**ESSO PETROLEUM COMPANY LIMITED: DCO APPLICATION FOR THE  
SOUTHAMPTON TO LONDON PIPELINE PROJECT  
DEADLINE 3 SUBMISSIONS BY SPELTHORNE BOROUGH COUNCIL**

Esso Petroleum Company Limited: Southampton to London Pipeline Project  
Development Consent Order application ♦ Project reference no. EN070005

### **Responses for Examination Deadline 3:**

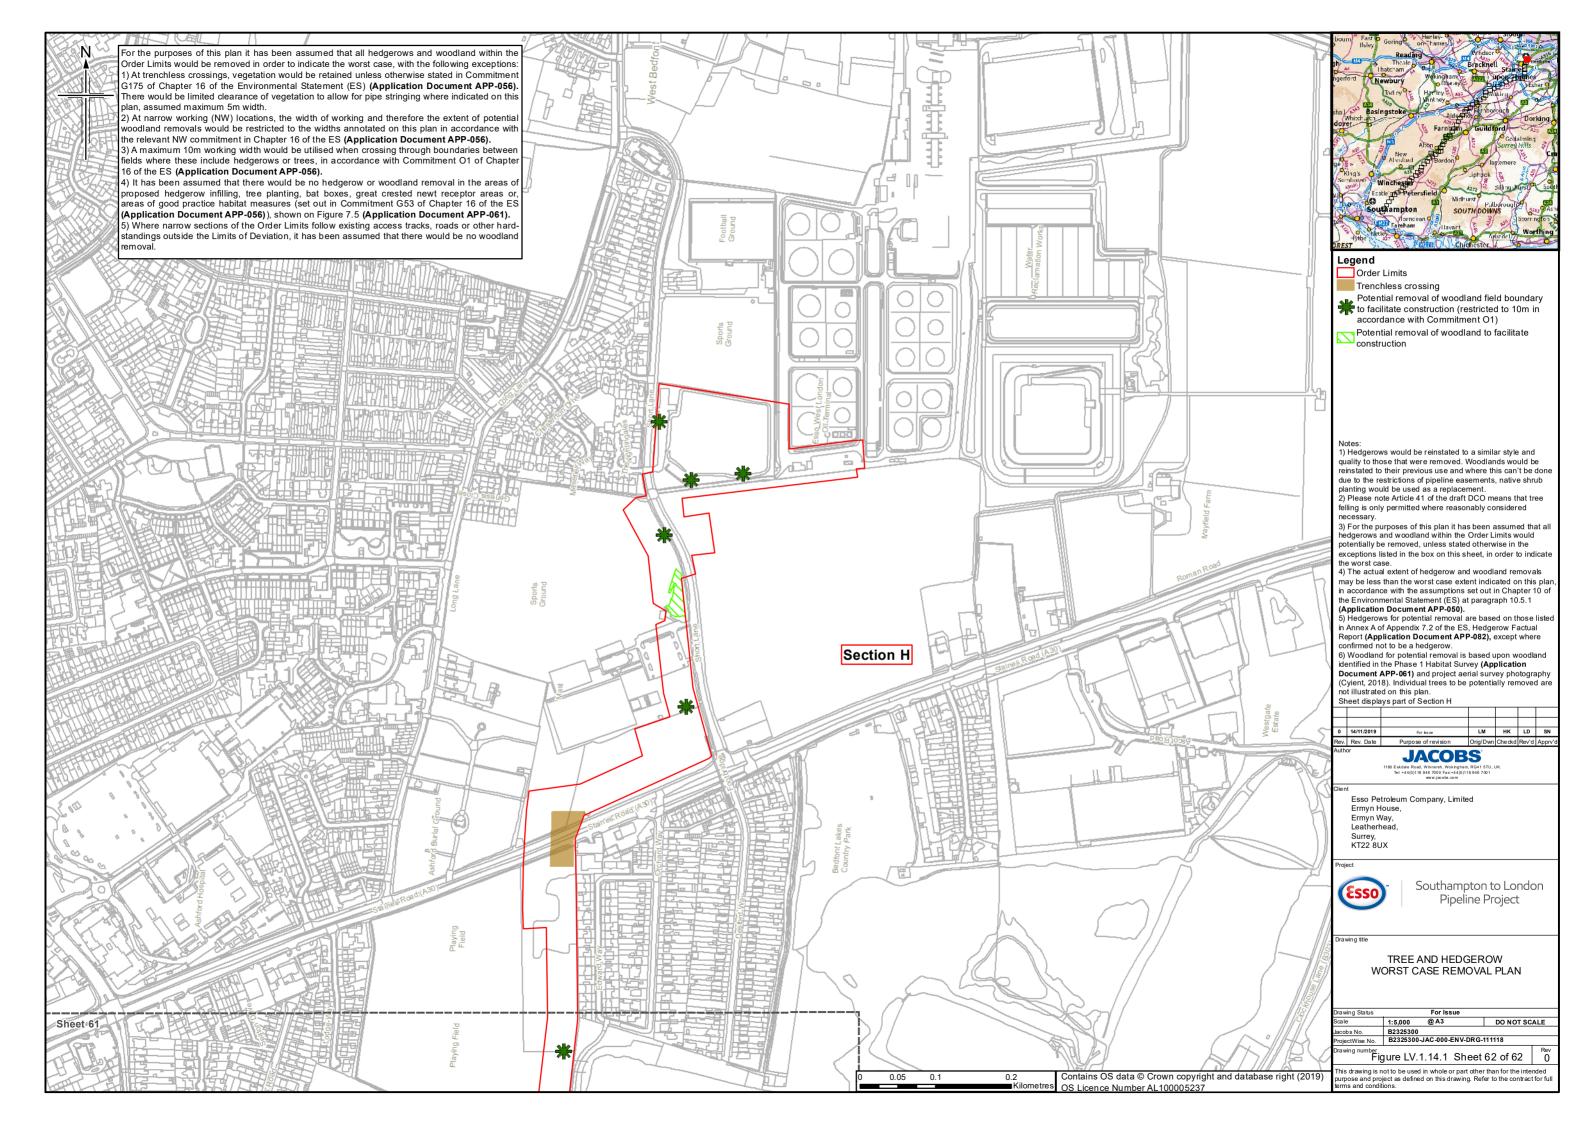
- 1.23 The general concerns summarised in the preceding paragraphs are well illustrated at Ashford Road and Fordbridge Park in Spelthorne. Sheet 60 of 62 of the 'worst case' tree and hedgerow removal plans supplied by Esso in its *Response to the Examining Authority's First Written Questions Landscape and Visual* document (REP2-046, document 2 of 2) shows a near-complete removal of woodland on the north-eastern edge of the park. This woodland currently provides visual containment of the public open space from the busy A30 Staines by-pass to the north, and includes various memorial trees. This level of impact would be entirely unacceptable. Esso's project team has given verbal reassurances that the actual construction impacts would be less severe but the DCO as drafted would enable tree removal up to the worst case scenario.

- 1.24 In contrast, no tree loss is predicted in Sheet 60 of 62 of the 'worst case' tree and hedgerow removal plans along Ashford Road other than at the small valve enclosure towards the northern end of the road. SBC is concerned that the plan overlooks the potential for harm to root systems from TPO-protected trees on the eastern verge of Ashford Road, which at worst could lead to tree loss. This line of trees is an important landscape and amenity feature and screens views of the

mineral workings beyond. Again, the level of impact is currently unknown but the Order would allow the pipeline to be laid close to the eastern verge of Ashford Road, where harm to root systems would be inevitable.

- 1.25 The measures proposed in paragraph 1.21 (above) would afford superior protection to valued trees in Ashford Road and Fordbridge Park.
